CR2011/000741
SF2011/002256
MM

13 February 2012

**MP11_0087 – PROPOSED REDEVELOPMENT OF WAGGA WAGGA BASE HOSPITAL –
STAGE 1A, EDWARD STREET, WAGGA WAGGA.**

FIGURE 27: Replacement Car Park

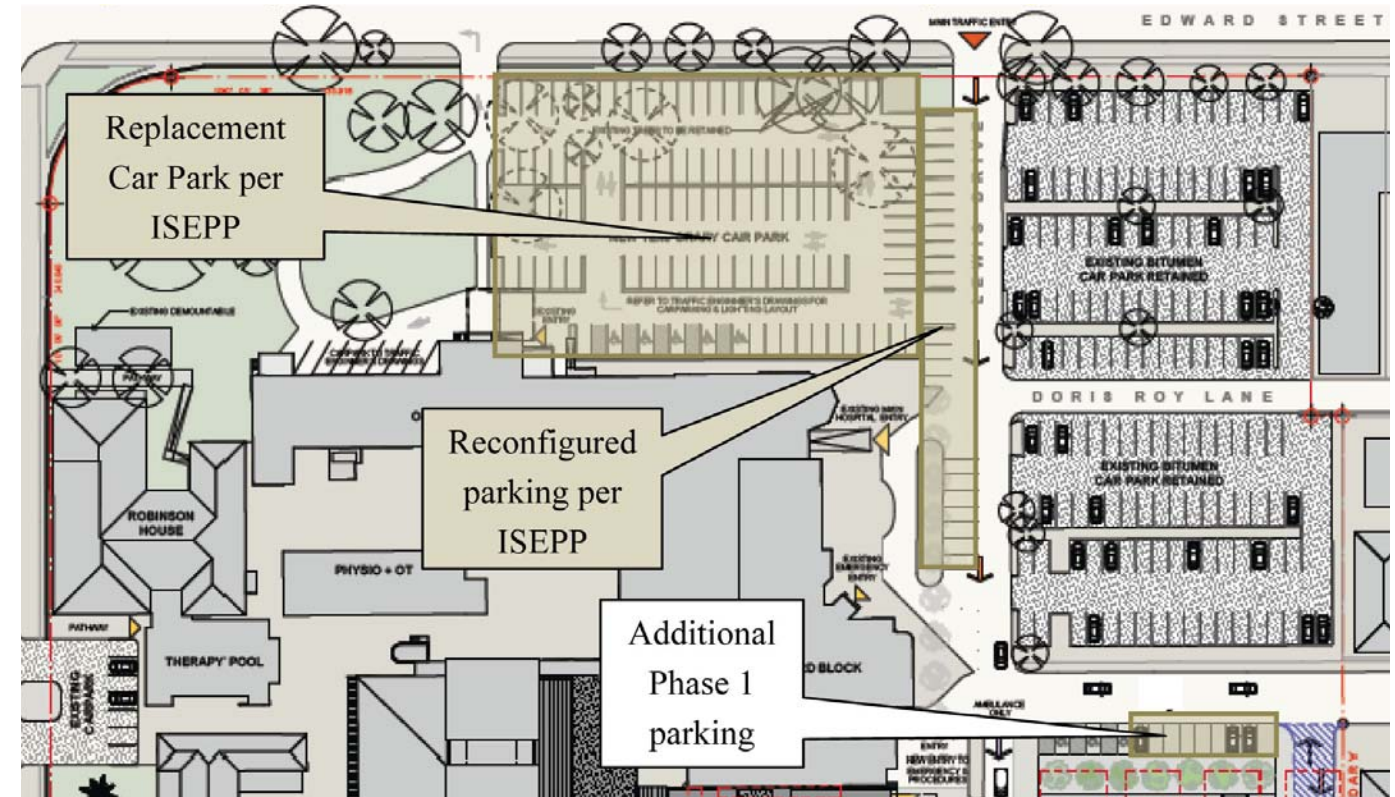
The exhibited documents proposed 2 different layouts for the carparks along the Edward Street frontage of the hospital site. It is understood that the carpark design for the existing and proposed carpark along the frontage of the hospital site to Edward Street is to be as per the layout on plan AR.GE.70.7001 Issue F included in the Test of Adequacy document dated November 2011. RMS notes that the proposed carpark works are being undertaken under the provisions of State Environmental Planning Policy (Infrastructure). RMS generally supports the proposed layout of the new carpark to the western side of Lewis Drive and the changes to the carpark on the eastern side of Lewis Drive and offers the following comments:

- The closure of vehicular access between the northern most aisle of the existing carpark located in the north eastern corner of the site and Lewis Drive is supported. To allow for ease of circulation within the carpark the provision of left turn egress only from the carpark to Lewis Drive and one-way circulation should be considered. The kerb and gutter and signage could be designed and located to support this and deny left turn from Lewis Drive into this carpark.

- The removal of the existing 90 degree parking located along the western side of Lewis Drive as shown on plan AR.GE.70.7001 Issue F is supported
- The location of one access from Lewis Drive to the new carpark to be constructed in the north western precinct of the site at the southern most aisle is supported.

- The existing driveway egress from the proposed new carpark to Edward Street should be deleted if it is not required for emergency purposes. Notwithstanding this, this driveway is to

be restricted to authorised vehicles by appropriate means, such as boom gate, as there would be a tendency for visitors parking within the new carpark to use this existing driveway. As a minimum signage is to be erected denying access to Edward Street is to be erected.

- To improve the traffic management and interaction with the existing road network RMS would consider an option for the construction of a driveway connection from the new carpark to Docker Street. To maximise the separation of a new driveway to Docker Street from the nearby traffic signals at the intersection of Docker and Edward Streets the driveway would need to be located at the western extension of the southern east west aisle within the new carpark. This option would require the one-way movement within the carpark as proposed, an appropriately designed driveway treatment in Docker Street and traffic calming devices to minimise speed for through vehicles between Lewis Drive and Docker Street. To remove the driveway to Edward Street and provide access to Docker Street may allow for additional parking spaces or landscape provision to be provided.

- The layout of the proposed carpark should comply with the provisions of AS 2890.1-2004 "Off-street car parking" and be designed and provide facilities for safe pedestrian movement though the carpark to the entrance to the Hospital.

- Provision for appropriate illumination and surveillance of the carpark is required.

FIGURE 28: Proposed Phase 1 Traffic Circulation

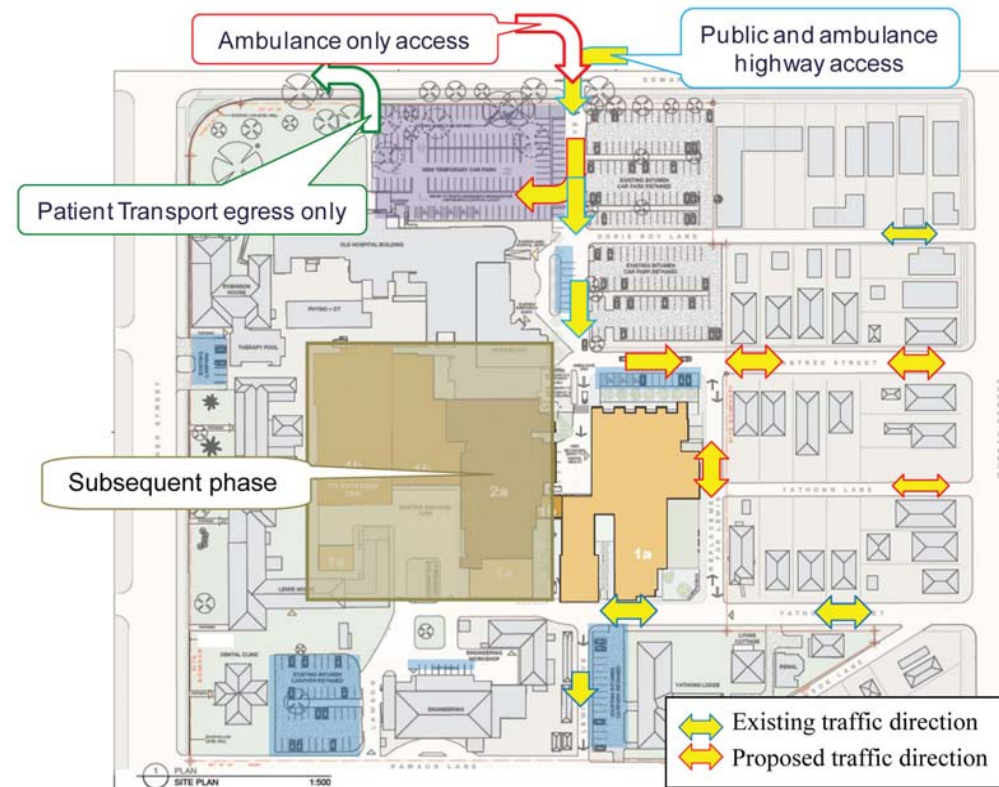
To provide for onsite circulation without the need to access the public road network and for ease of way finding within the site the proposed new road between Yathong and Yabtree Streets to the east of the Mental Health Building needs to provide for 2 way movement, not one-way as proposed in the Test of Adequacy document dated November 2011. This will also benefit circulation within the site and access for delivery vehicles when Yathong Street is extended to intersect with Docker Street. Representatives from NSW Health Infrastructure have advised that this roadway is to provide for two-way movement as the proposed width of 7m can catered to this.

- a. The new internal road located to the east of the Mental Health Building between Yathong and Yabtree Streets is to be designed, constructed and line marked to provide for 2 way movement for all vehicles likely to access the hospital site.
